CITY OF ALBUQUERQUE

October 4, 2022

Re: Building A & Building B
543 Old Coors Rd. SW
Traffic Circulation Layout
Architect's Stamp 07-21-22 (K11-D027)

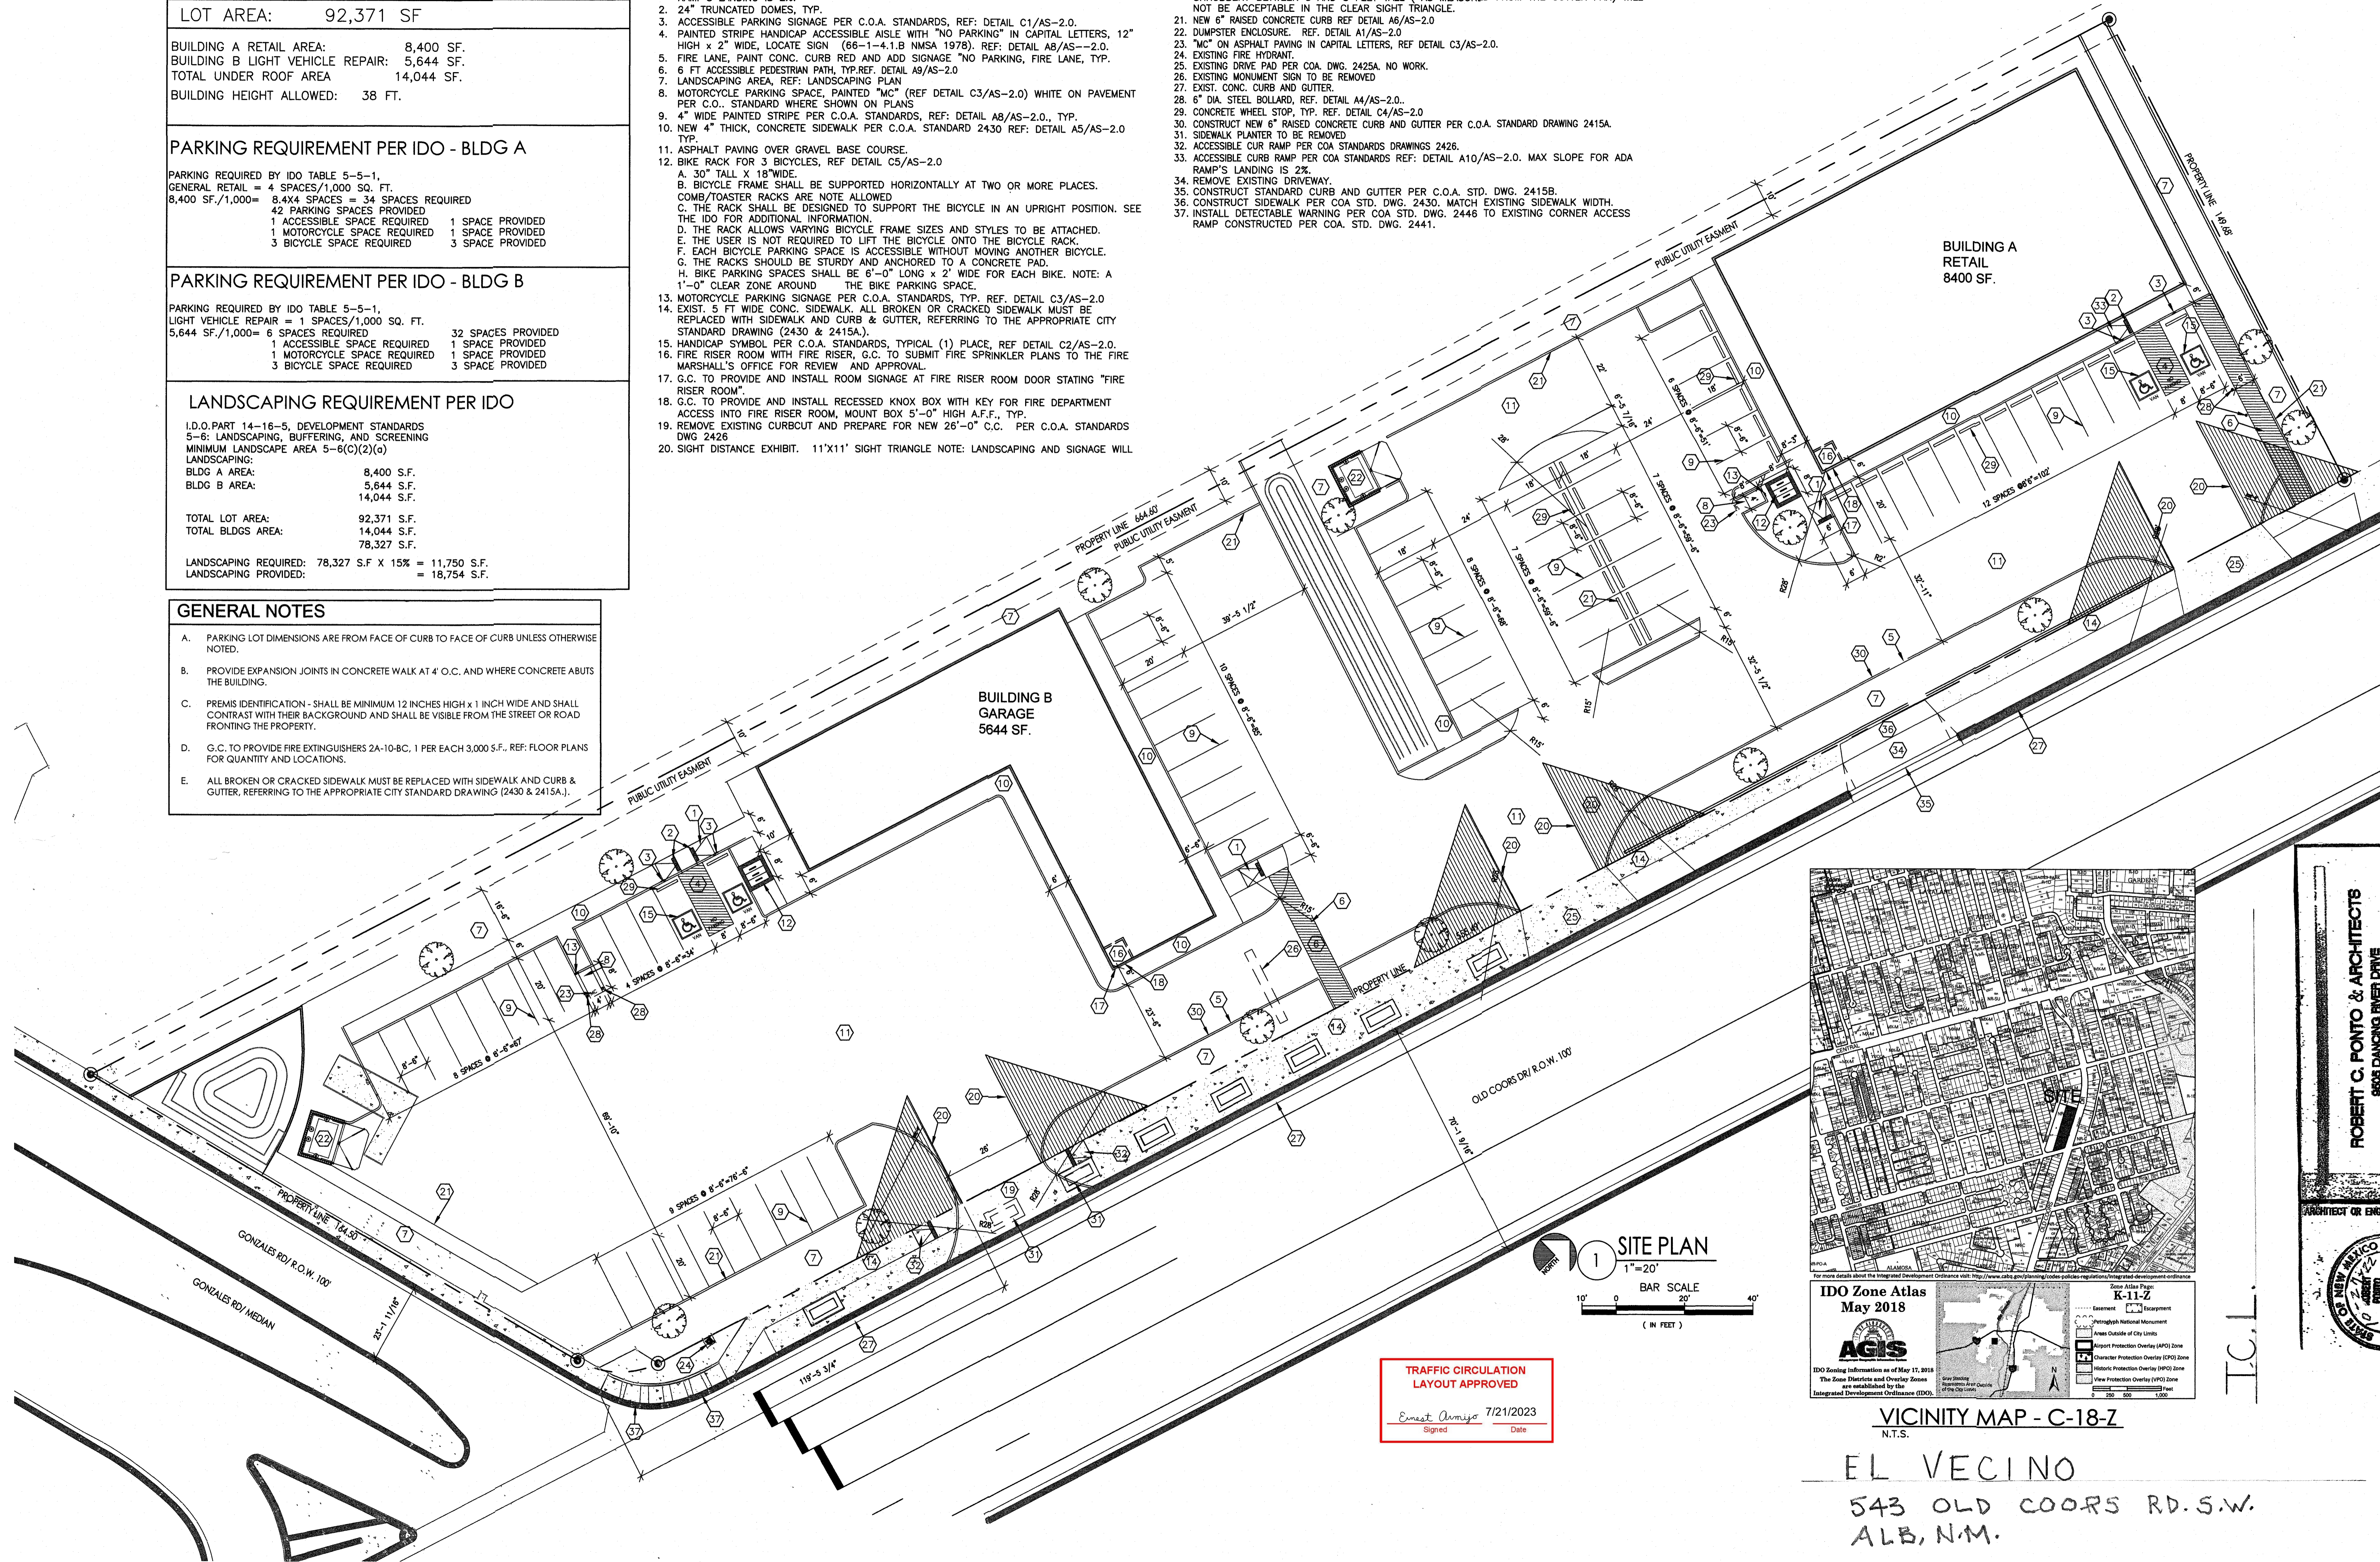
1. Identify the right of way width, medians, curb cuts, and street widths on Old Coors Rd. and on Gonzales Rd.
2. Building A: Per NMBC Table 1106.1, the number of ADA parking spaces required is 2 spaces. Please see attached.

3. Please provide Curb Return design for all Driveways Accesses off Old Coors Rd. SW. and reference COA std dwg 2426.
4. Per the DPM table 3.2-2 the distance from the proposed driveway access to the intersection should 100 ft. Please note that the Old Coors classified as Minor Arterial, and Gonzales Rd classified as Local Street. See attached.

6. ADA curb ramps at the corner of Old Coors Rd. and Gonzales Rd. must be updated to current standards and have truncated domes installed. Please provide details for the existing ADA ramp.

7. Please remove the reference 2426 from key note 1. And add a note "The max. slope for the ADA ramp's landing area is 2% in all directions".
8. A 5 ft. keyway is required for dead-end parking aisles.

11. Please specify the City Standard Drawing Number when applicable.
12. Unused curb cuts must be replaced with sidewalk and curb & gutter. A build note must be provided referring to the appropriate City Standard drawing.

A7 ACCESSIBLE RAMP
NOT TO SCALE

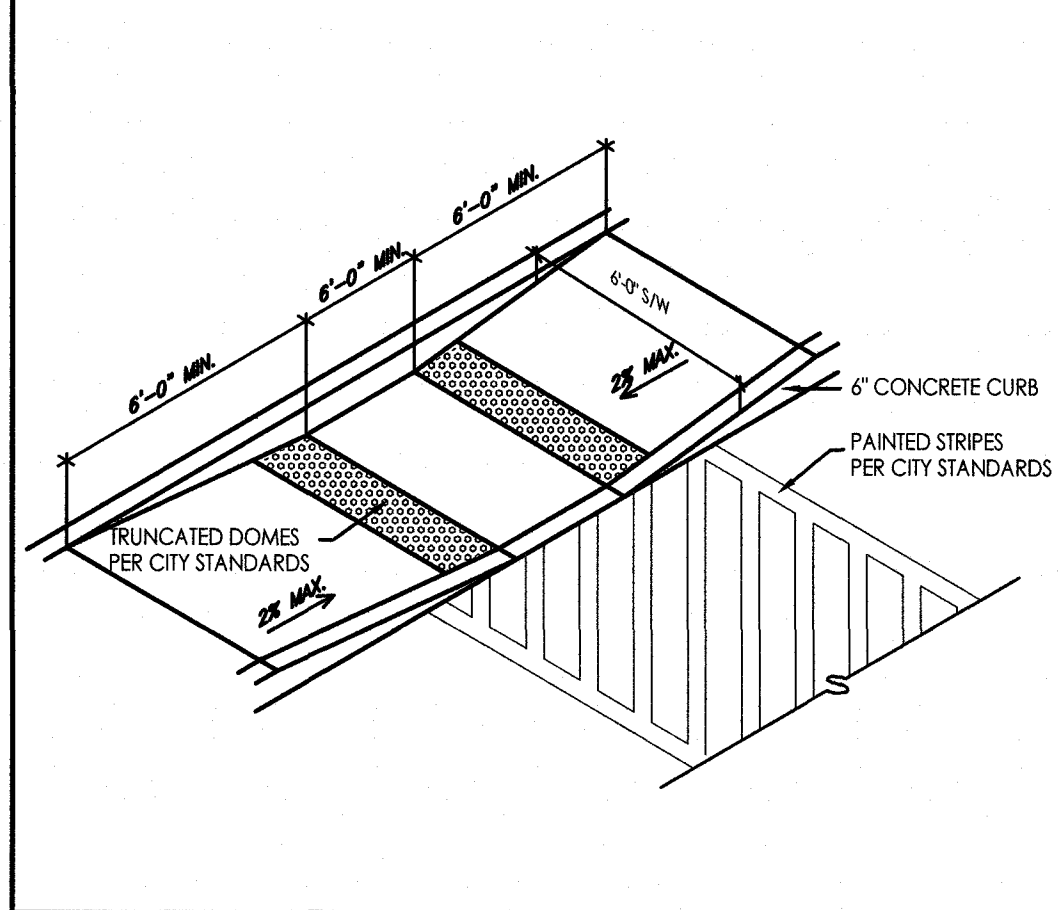
5. Sheet details (the detail A7), where is the location for this ramp on the site plan? Please note that he landing area dimensions should be min. 5' x5'
